Development Facilitation Team (DFT) – Review Comments

Project No: PR-2023-008660 Date: 5/24/2023 Agenda Item: #4 Zone Atlas Page: H-14

Location: 601 Aspen Ave NW

Application For: SD-2023-00103 – Preliminary/Final Plat (DHO)

**Plat for
 Lot 1-A, Block 5
 Ives Addition
 Being Comprised of
 Lots 1 Thru 4, Block 5
 Ives Addition
 City of Albuquerque, Bernalillo County, New Mexico
 March 2023**

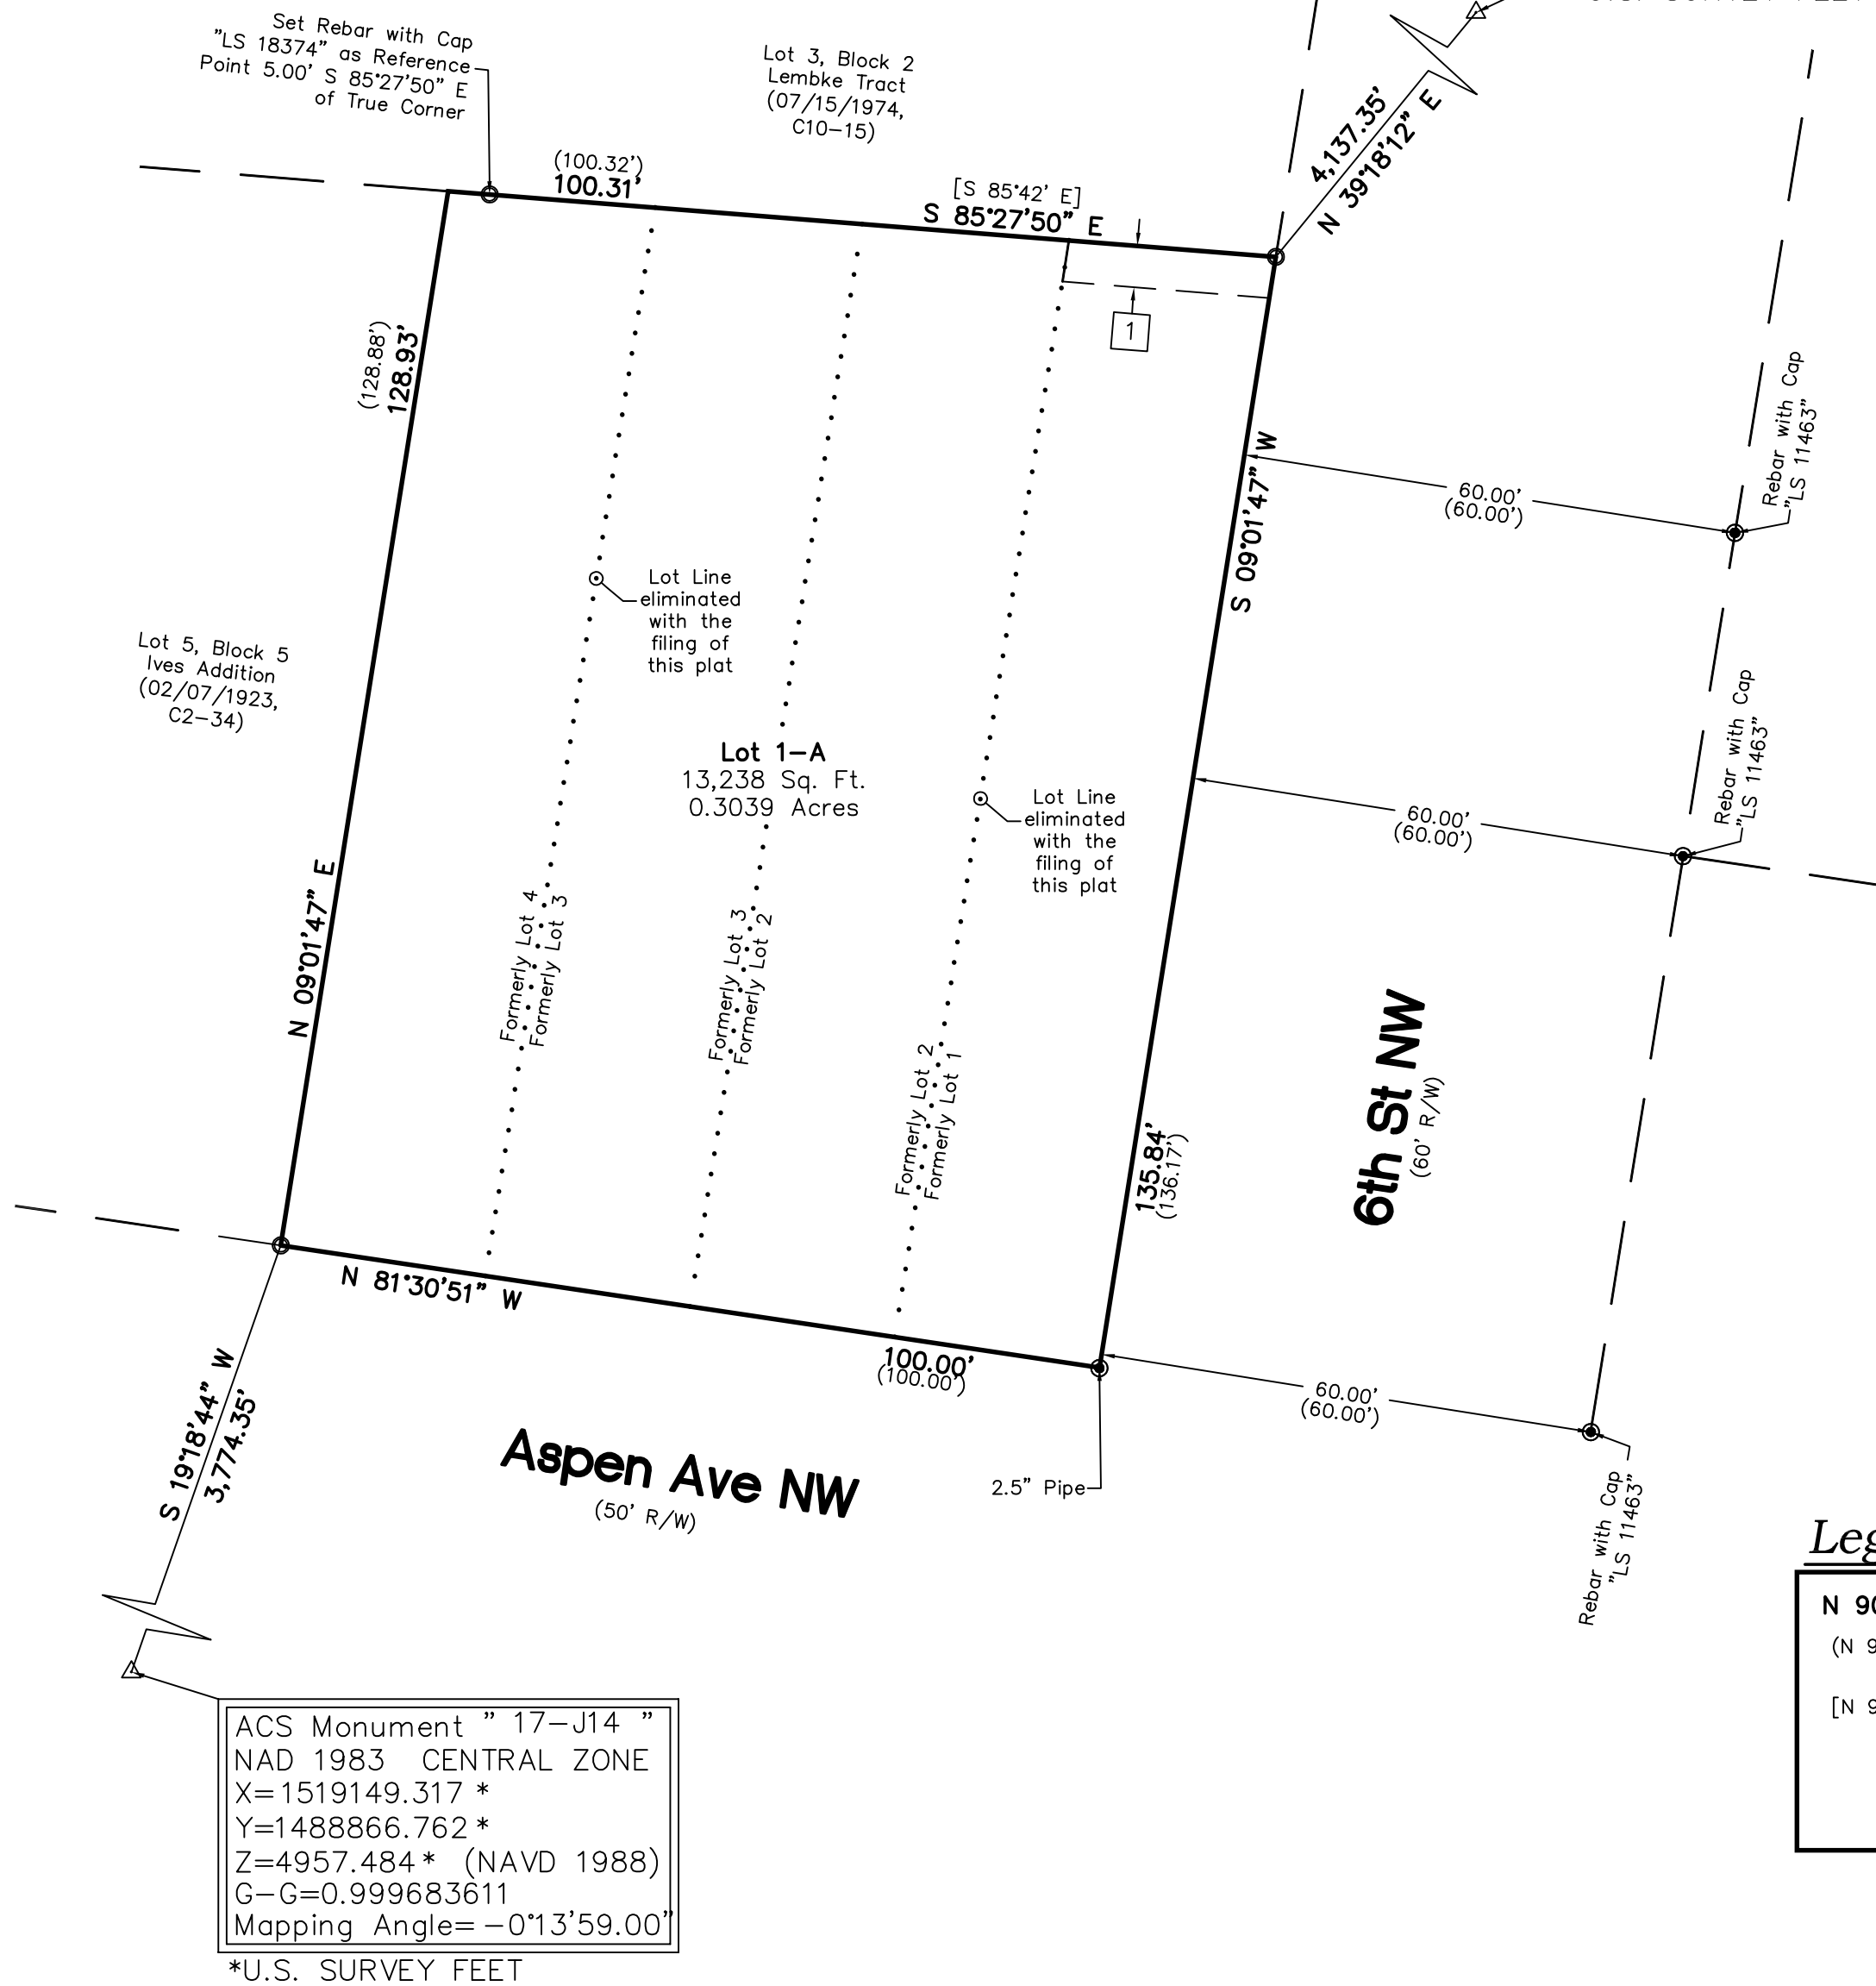
1. 6th Street is a minor arterial and requires 6' sidewalks with a 5-6' landscape buffer. Aspen is a local street and requires 5' sidewalk with a 4-6' landscape buffer. From the plat it appears there is adequate ROW to fit this in.
2. A Minor Arterial is required to have a minimum 82' ROW, while your plan shows only 60'. Please provide ROW dedication or request a determination with a justification letter explaining why the ROW cannot be provided.

- The parcel is zoned NR-LM (Non-Residential-Light Manufacturing) district. The application needs to be **corrected to show the correct zone**.
- There is a current building permit under review (BP-2023-01285). Provide more detail on this permit.
- The **application number** must be added to the Plat prior to the final sign-off should the Plat be approved by the DHO.
- The **DXF file** must be approved by AGIS prior to final sign-off should the Plat be approved by the DHO.
- The site fronts on **Aspen Avenue** which is a Local Street. The required Sidewalk along Aspen Ave. is 5ft and the Buffer Zone/Landscape zone is 4-6 feet. The existing sidewalk is 3.4 feet.

The site is also bounded by **6th Street**, which is a Minor Arterial and has a proposed Bike Lane. Per DPM Table 7.2.29, the required Sidewalk along 6th St. is 6 feet and Buffer/Landscape is 5-6 feet. The current sidewalk is 5 feet.
